Re: Proposed Residential Apartment Building: 424 Churchill Avenue North

Addendum #1 to Traffic Impact Assessment Final TIA Report originally dated June 8,

2023 (Castleglenn Project 7303)

1 SITE PLAN  
 A002 1:100

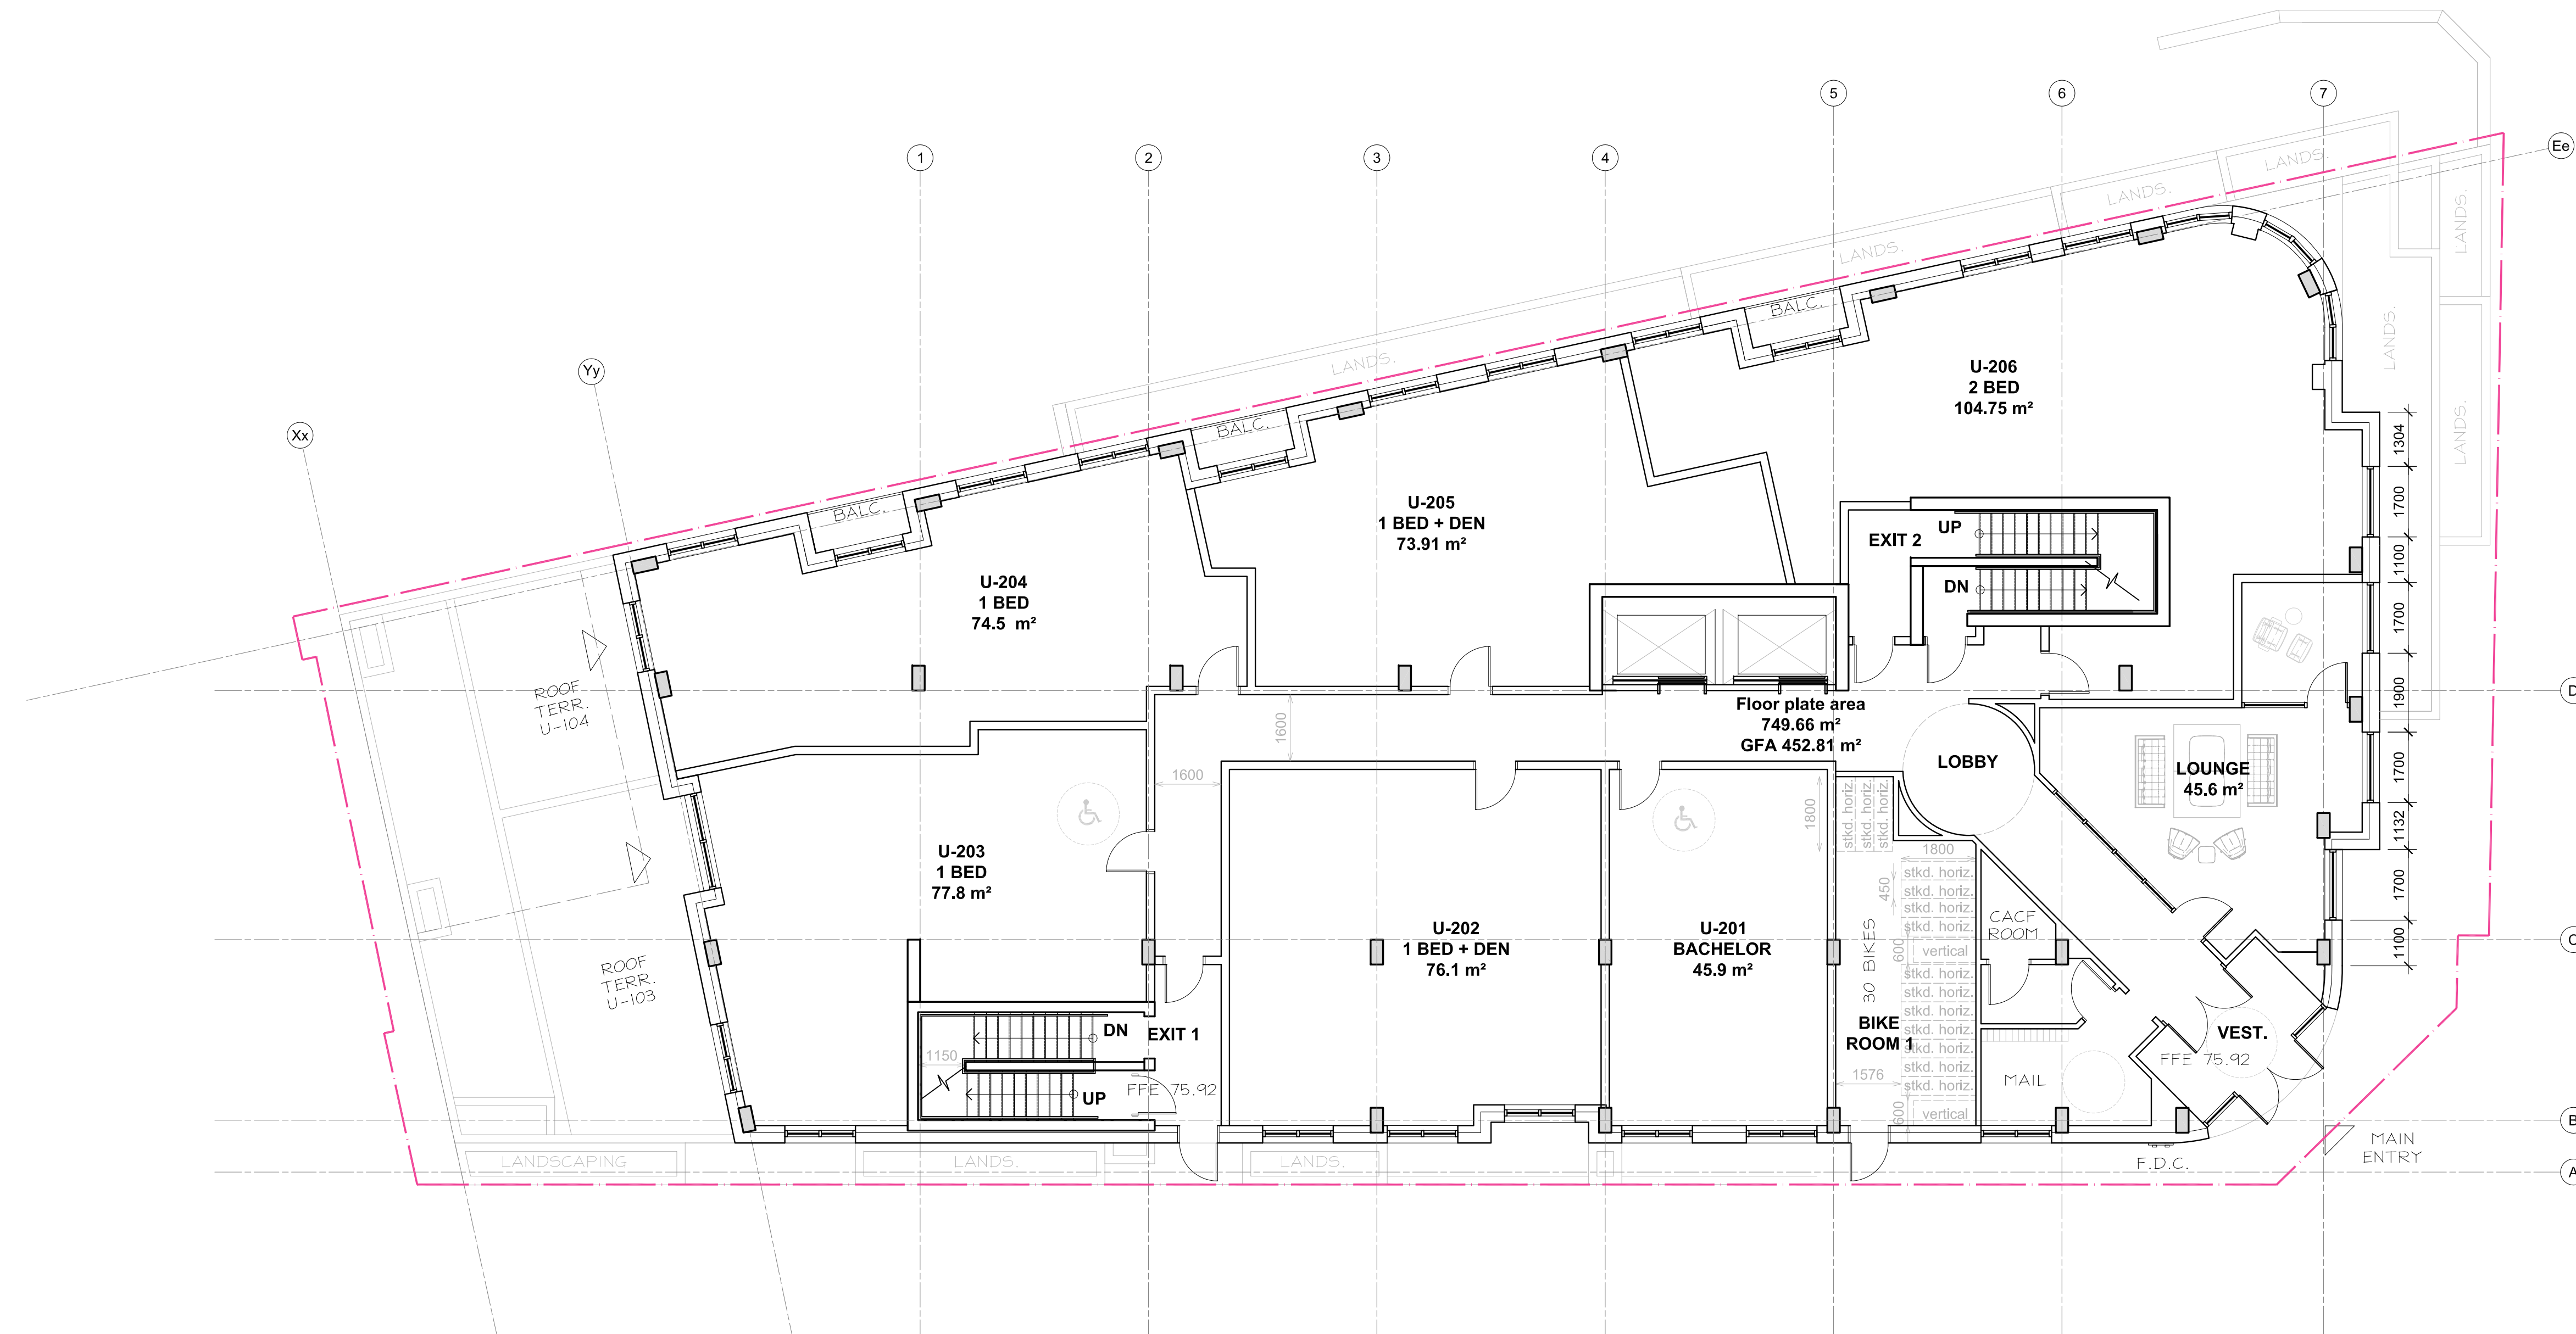
City of Ottawa staff has requested that the 5x5 triangle at the northwest corner of Byron Avenue and Churchill Avenue North intersection be protected from development, including any below-grade obstructions. This resulted in a change in site layout, including the two parking levels. The following amendments to the contents of the original TIA report dated June 8, 2023 are noted:

The site plan referenced in the original TIA report (dated April 19, 2023), referenced in section 4.1.1 (Exhibit 4-2) and Appendix "C" has now been superseded by new site plans prepared by Open Plan Architects Inc. dated February 23, 2024. The new site plan is provided in Attachment "A" to this letter.

| drawing no. | <b>A106</b> |          |             |

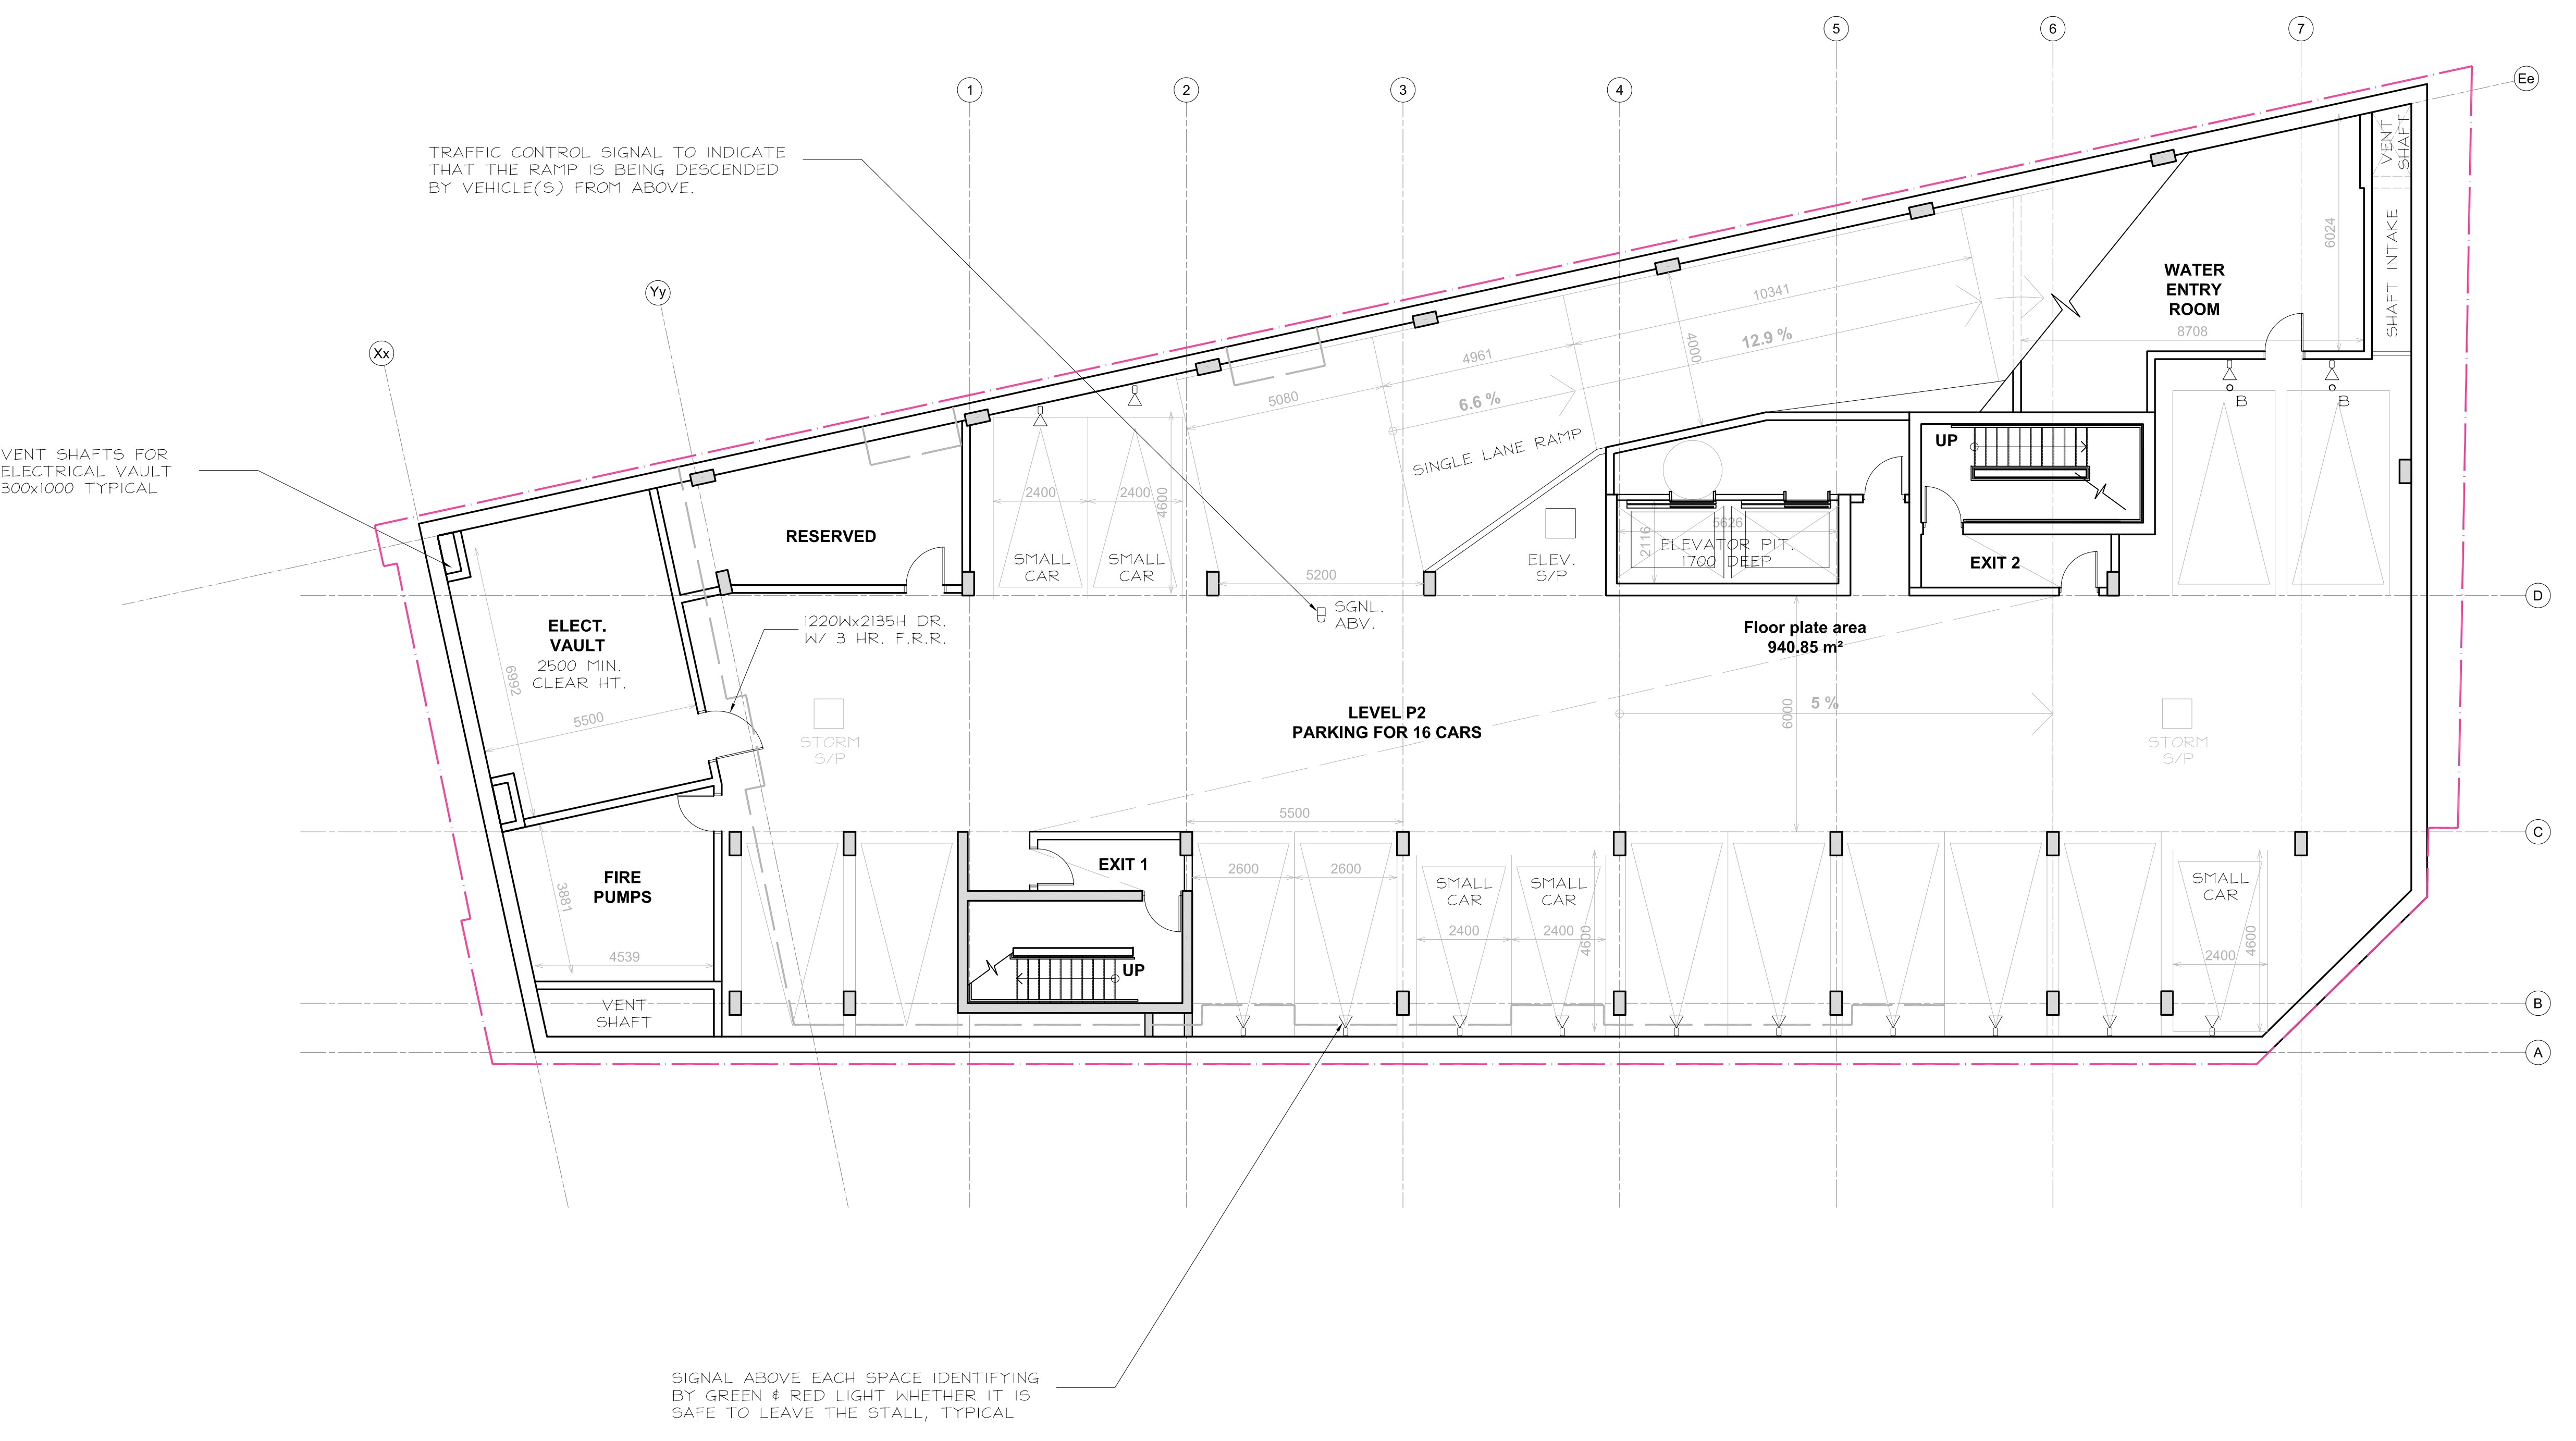
The parking supply referenced in the section 6.2.1 of the originally submitted report stated that 33 motor vehicle parking stalls are provided by the development. The constraints introduced by removing a 5x5 corner triangle from the building's underground parking levels resulted in a loss of two parking stalls in the easternmost corner of the parcel.

An updated Table 6-1 below provides an updated parking provision summary per new site plan, which totals to 31 stalls, representing a decrease of 2 residents' parking stalls – one stall on each parking level. The updated parking provisions (31 stalls) continue to meet the City of Ottawa's Zoning By-law requirement (28 stalls).
